# KITTITAS COUNTY FIRE MARSHAL'S OFFICE

Re: Walker (BL-10-00022) and (SG-10-00014)

After conducting a review of the above named project, I have the following comments:

EXHIBIT

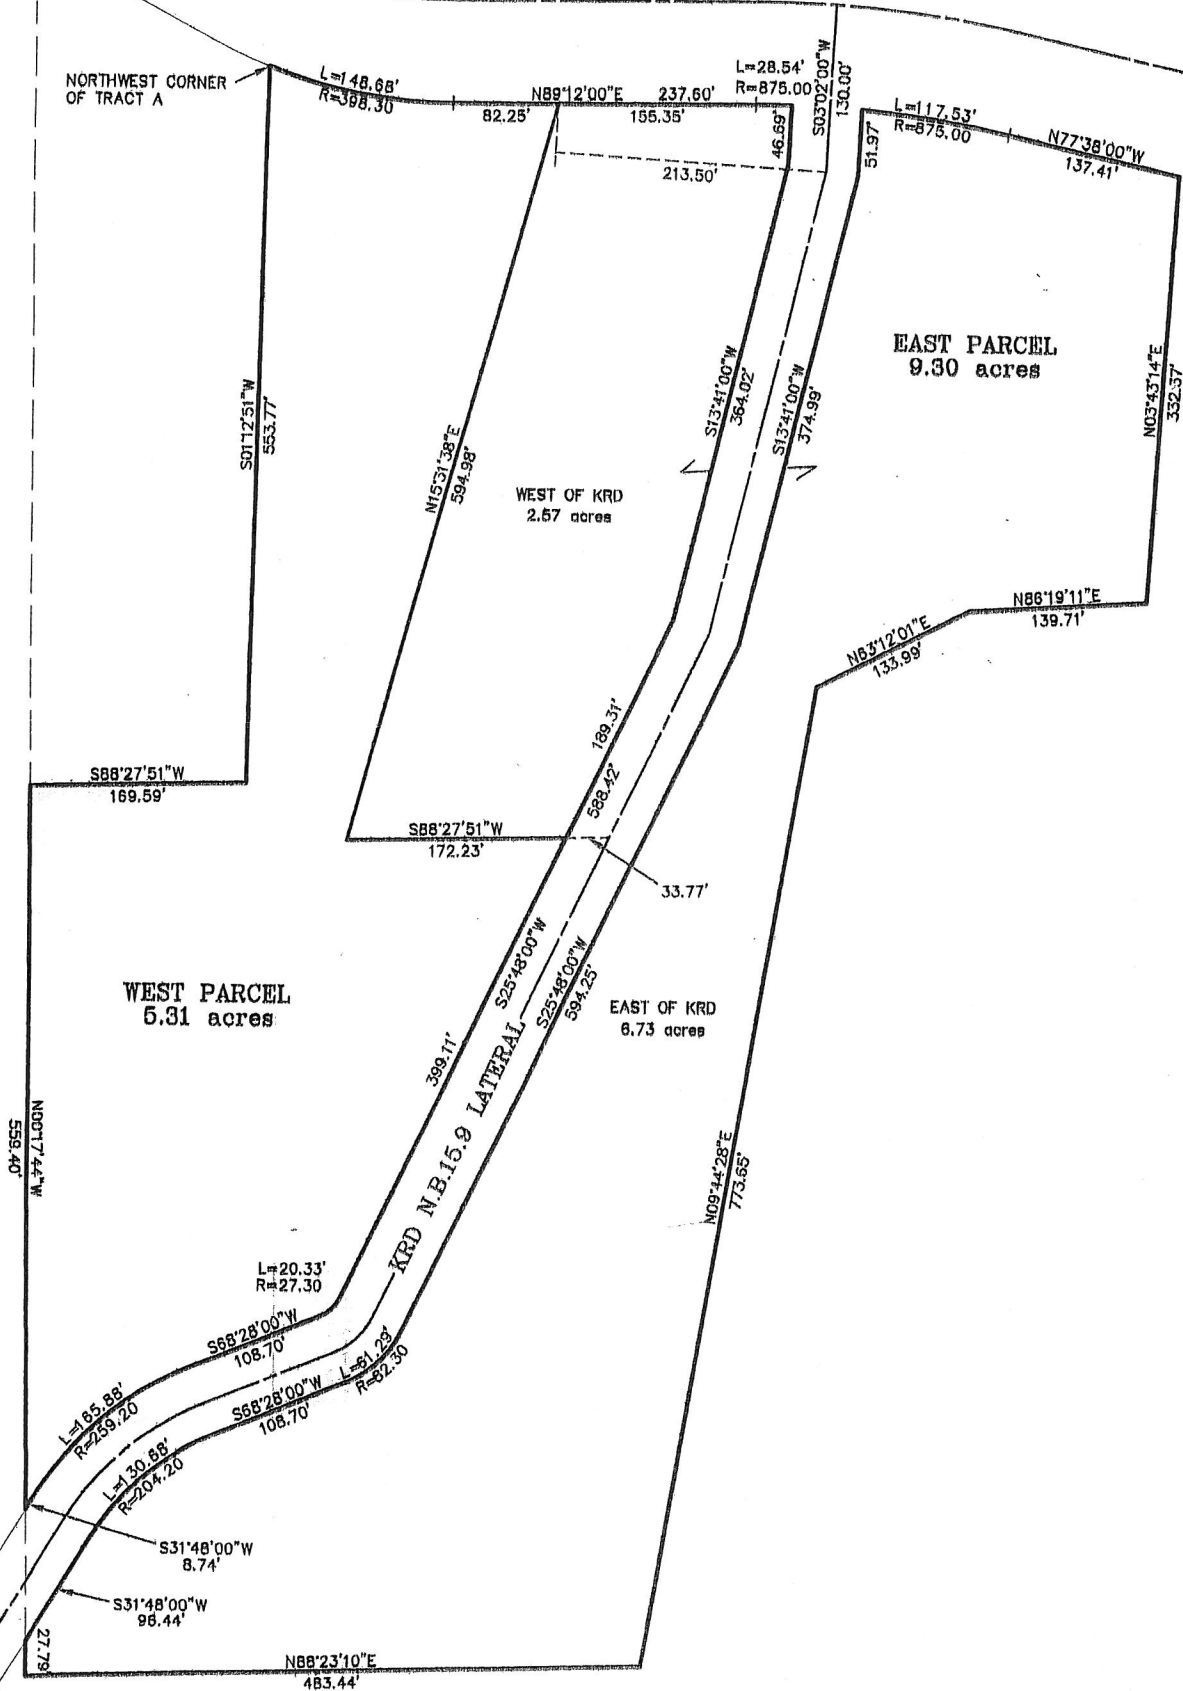
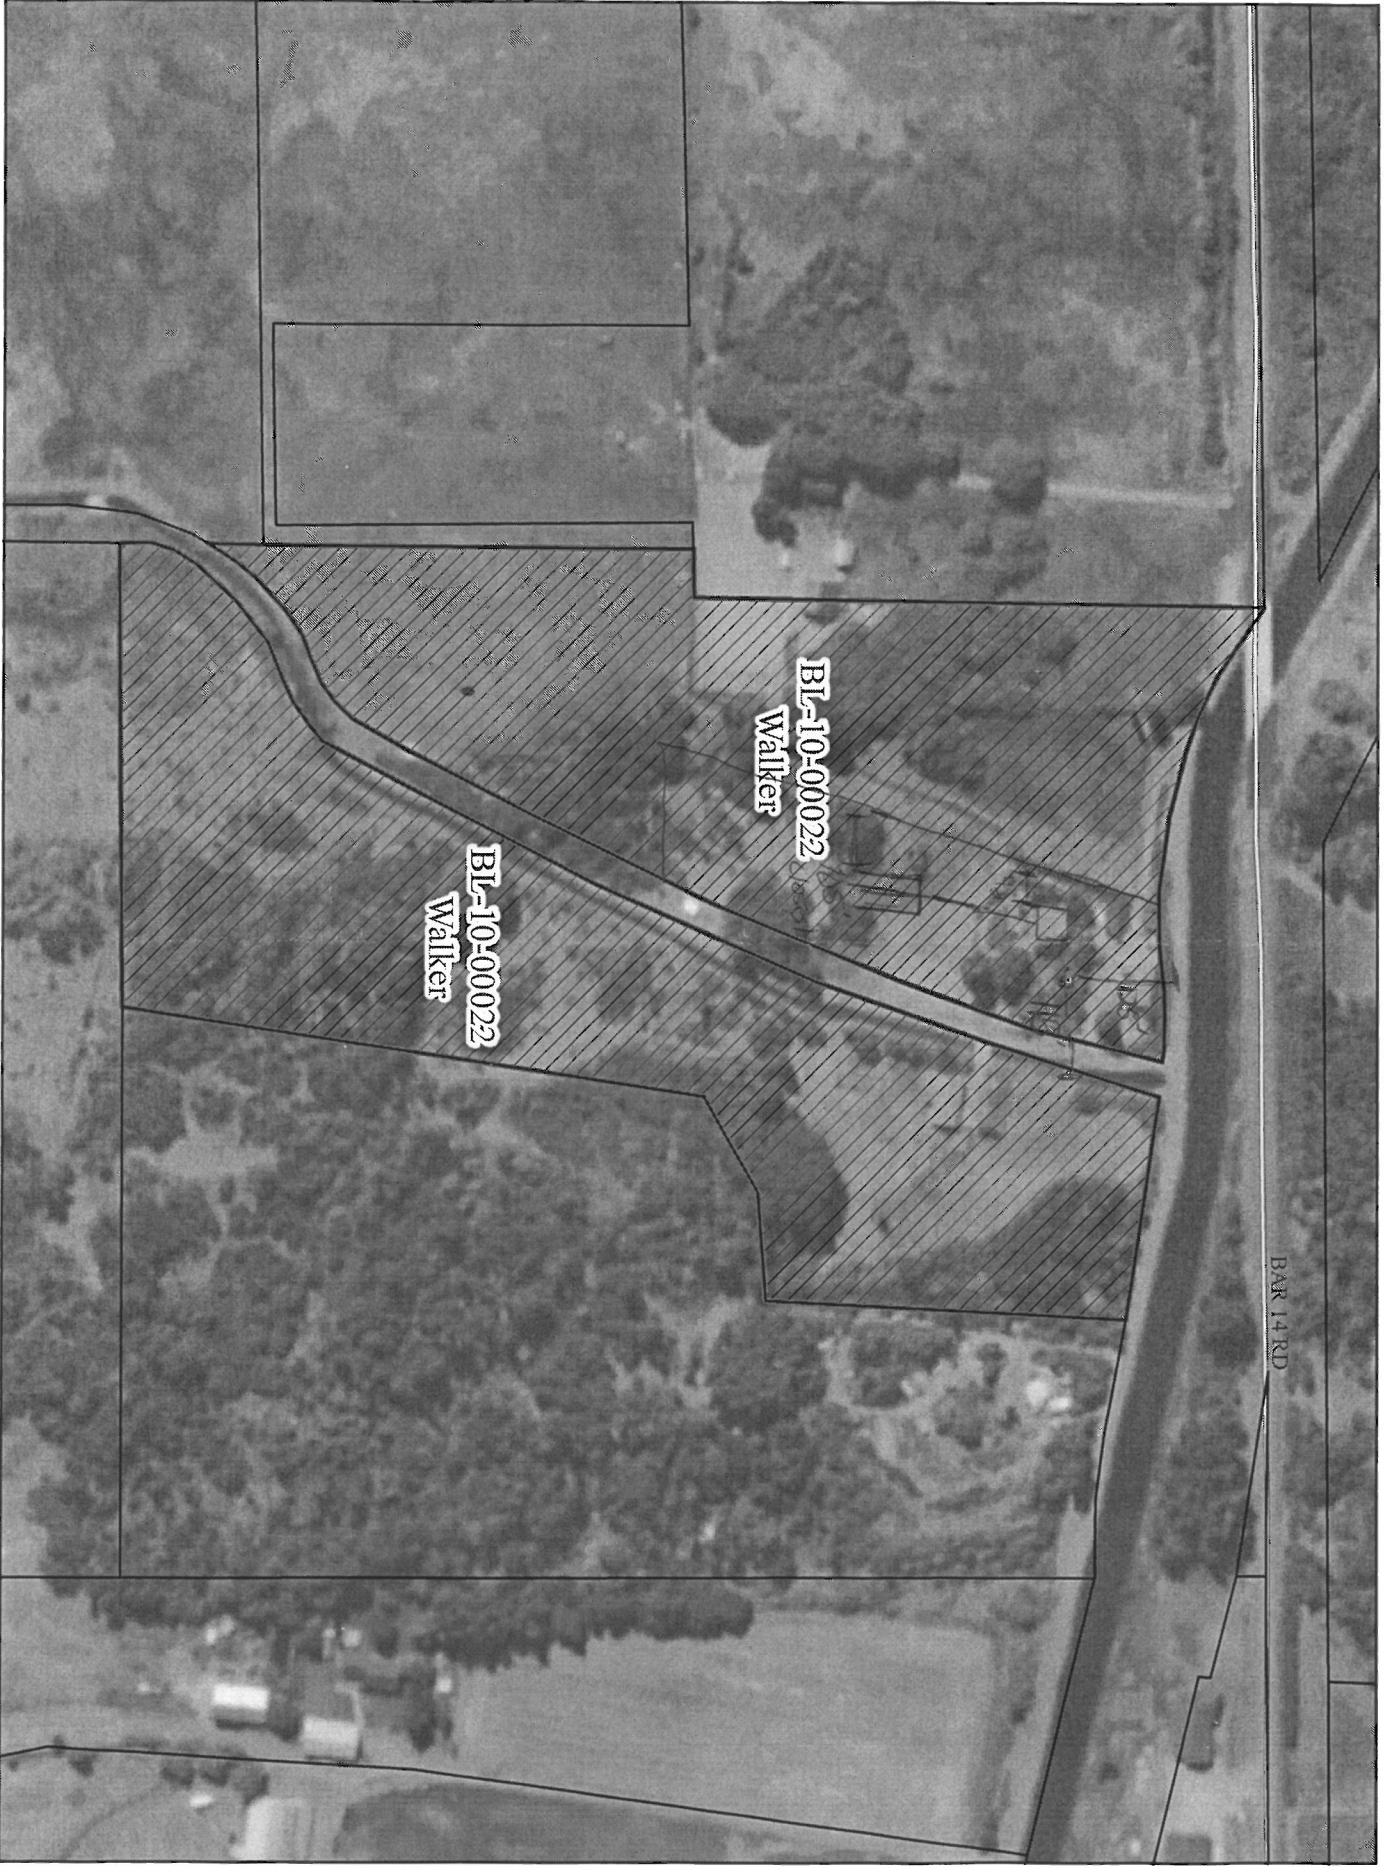
- Ensure that boundary line adjustments do not infringe upon existing structures, to include propane tanks, etc.
- All future development must comply with the International Fire Code.
